PATRIOT PLACE SUBDIVISION - REPLAT A

A REPLAT OF LOTS 1 & 2, PATRIOT PLACE, LOCATED IN THE SOUTHWEST QUARTER OF SECTION 11,
TOWNSHIP 11 SOUTH, RANGE 67 WEST OF THE 6TH P.M.,
COUNTY OF EL PASO, STATE OF COLORADO

FINAL PLAT
PATRIOT PLACE SUBDIVISION - REPLAT A

Final Plat Drawings_V1.pdf Markup Summary

SHEET 1 OF 2

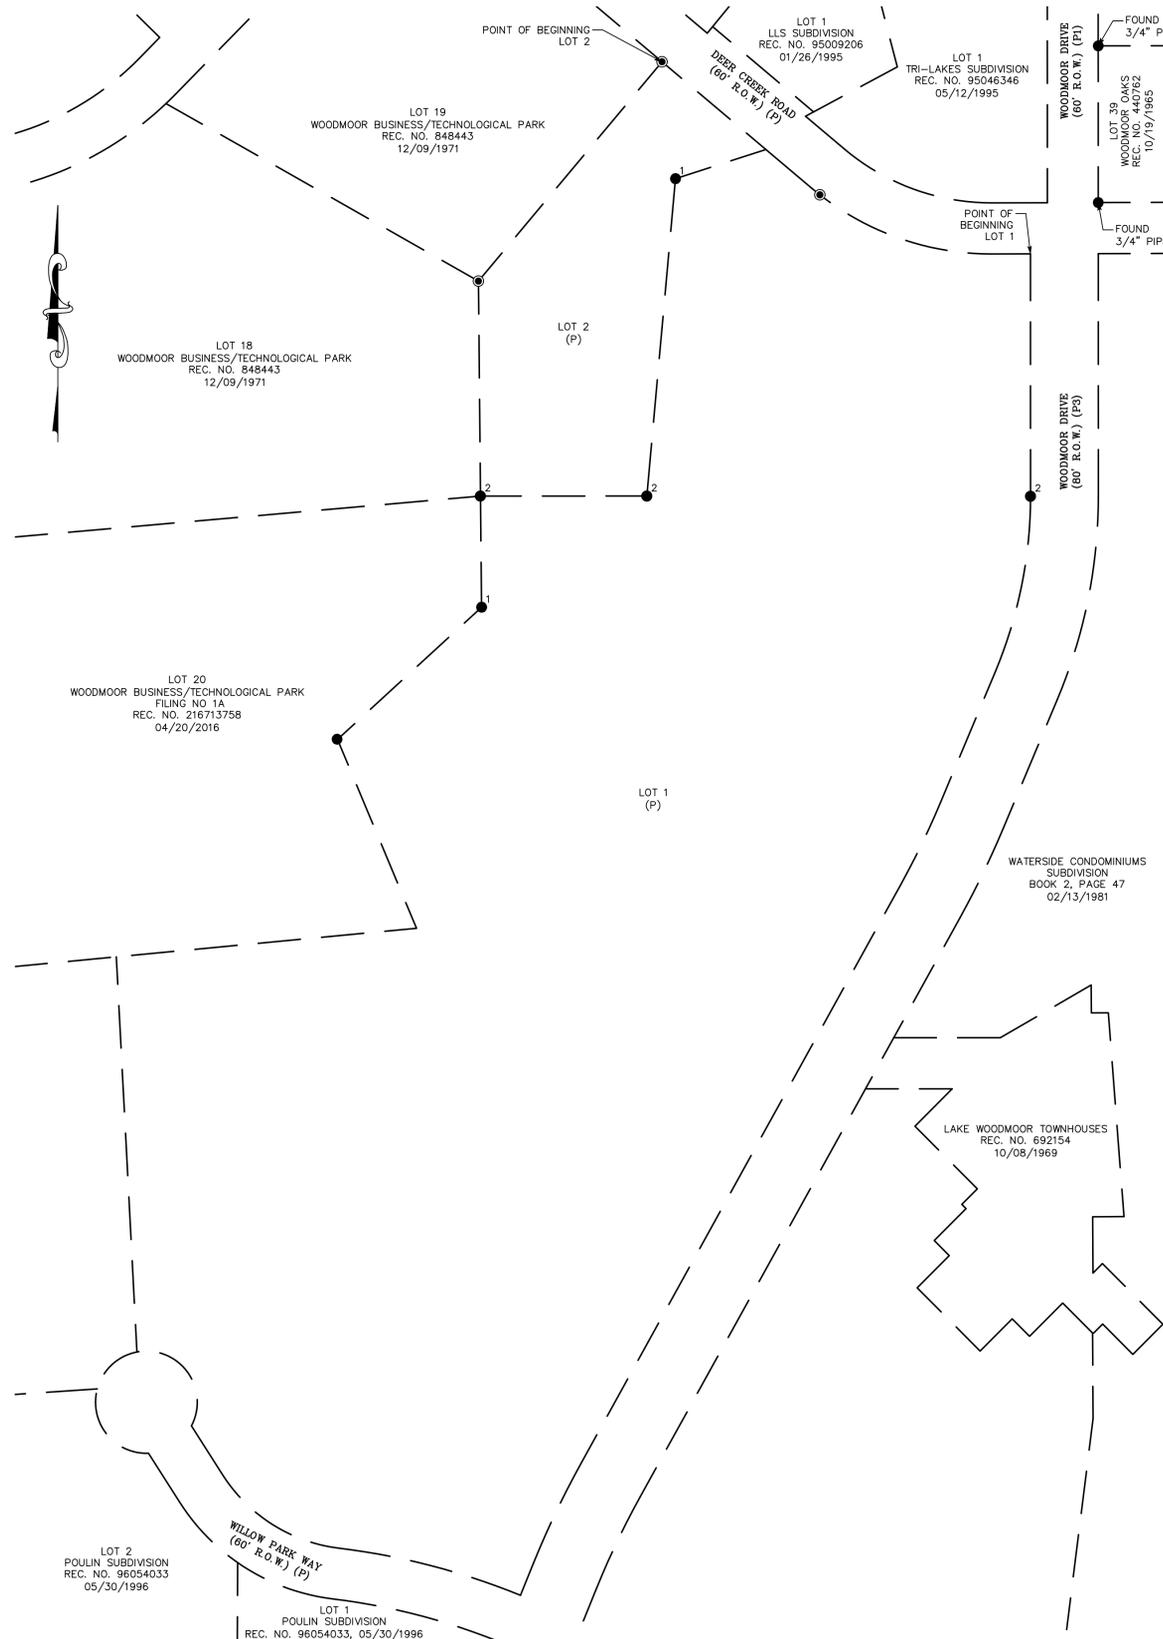
Please add all of the previous plat notes shown on the current plat (from 1993) in addition to the following:
-add reference to the covenants

Please revise title to say:
"PATRIOT PLACE SUBDIVISION - A"

Bearings on proposed plat do not match those on the existing plat, as such this legal description will also need to be revised accordingly along with the plat and closures sheet.

Add second signature block for second owner.

Remove Depositing Certificate altogether; not needed.

Add the following plat notes:

Please add the following note(s):
-All property owners are responsible for maintaining proper storm water drainage in and through their property. Public drainage easements as specifically noted on the plat shall be maintained by the individual lot owners unless otherwise

# PATRIOT PLACE SUBDIVISION - REPLAT A

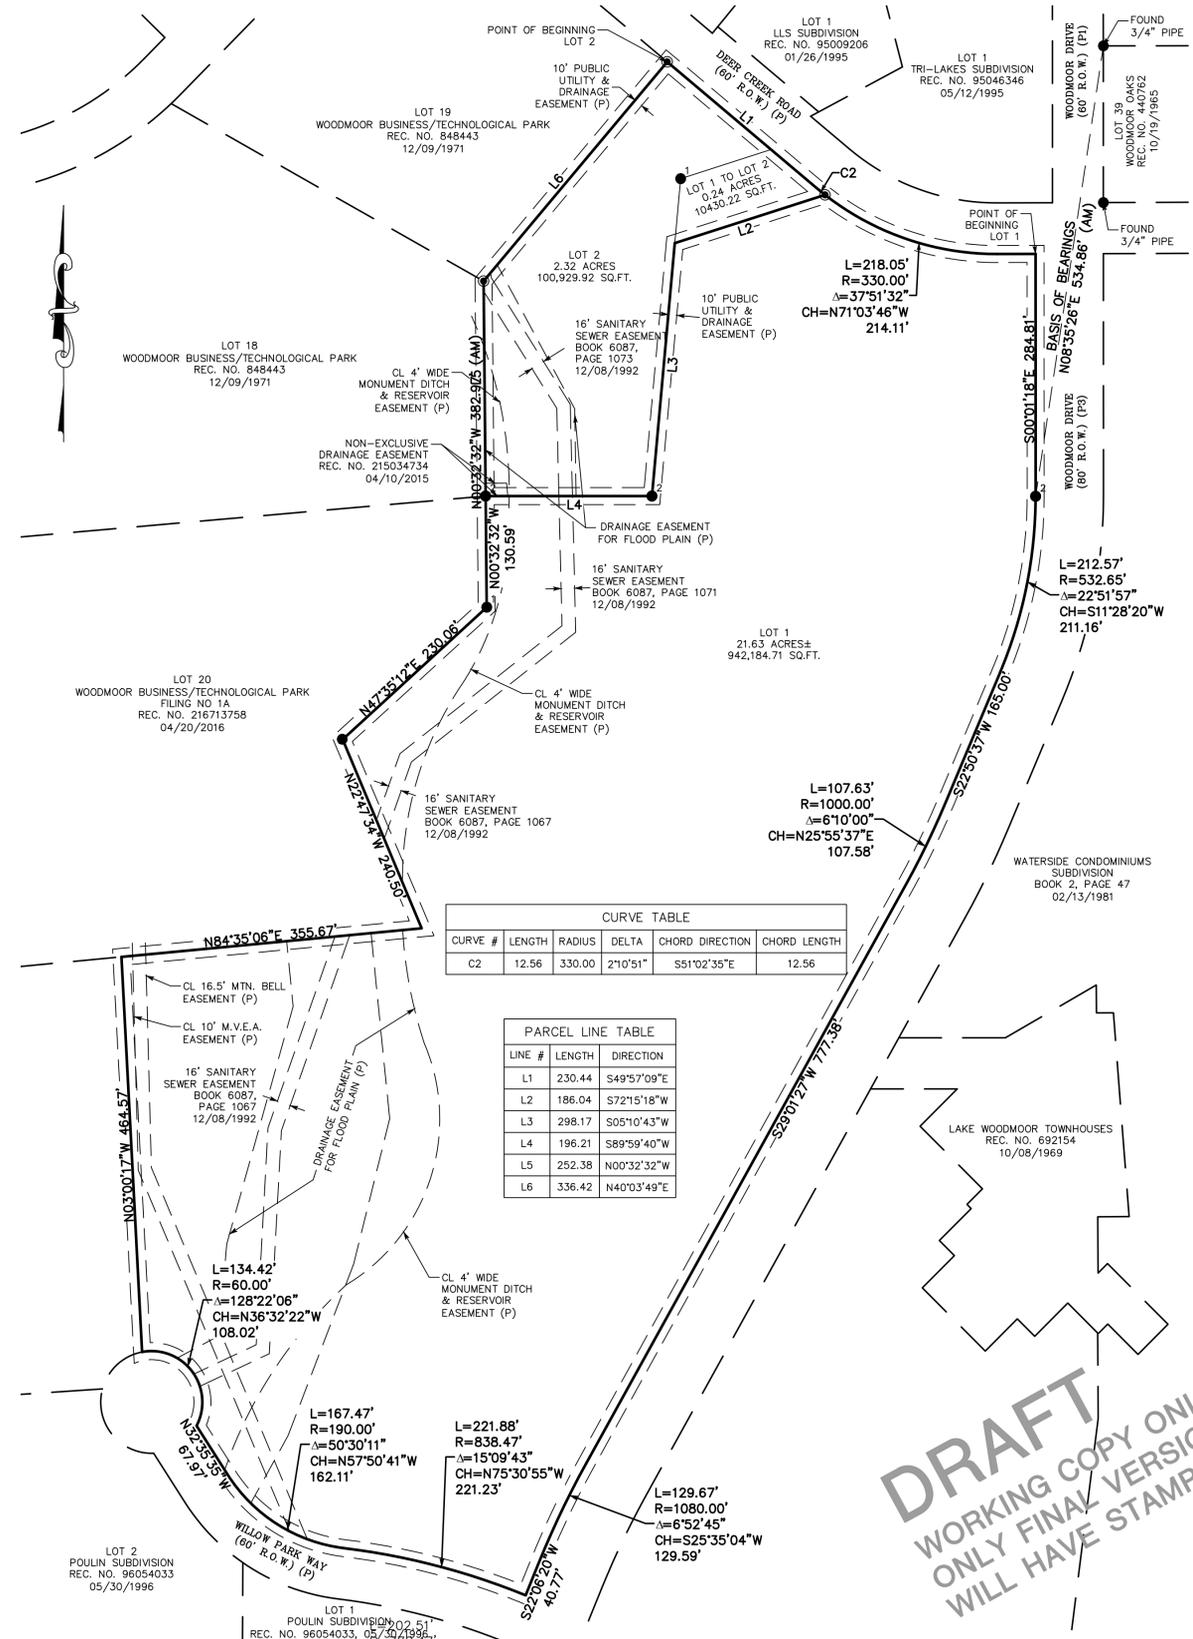
Does not show 50-foot electric easement for overhead electric lines per plat 8646.

Please provide the bearing and distance for the easements shown.

Also please delineate the FEMA Floodplain and show the FEMA baseflood elevations.

Page 1071 is referenced on existing plat.

Please add reception number included in the title commitment for this easement (item 12 on title commitment).

Please revise title to say:
"PATRIOT PLACE SUBDIVISION - A"

Revise and rename to read "LOT 1A TO LOT2A"

Measurements are considerably off from existing plat.
Other bearings along all property lines are also slightly off; please revise accordingly.

Please refer to comments to title commitment for items needing to be added to plat.
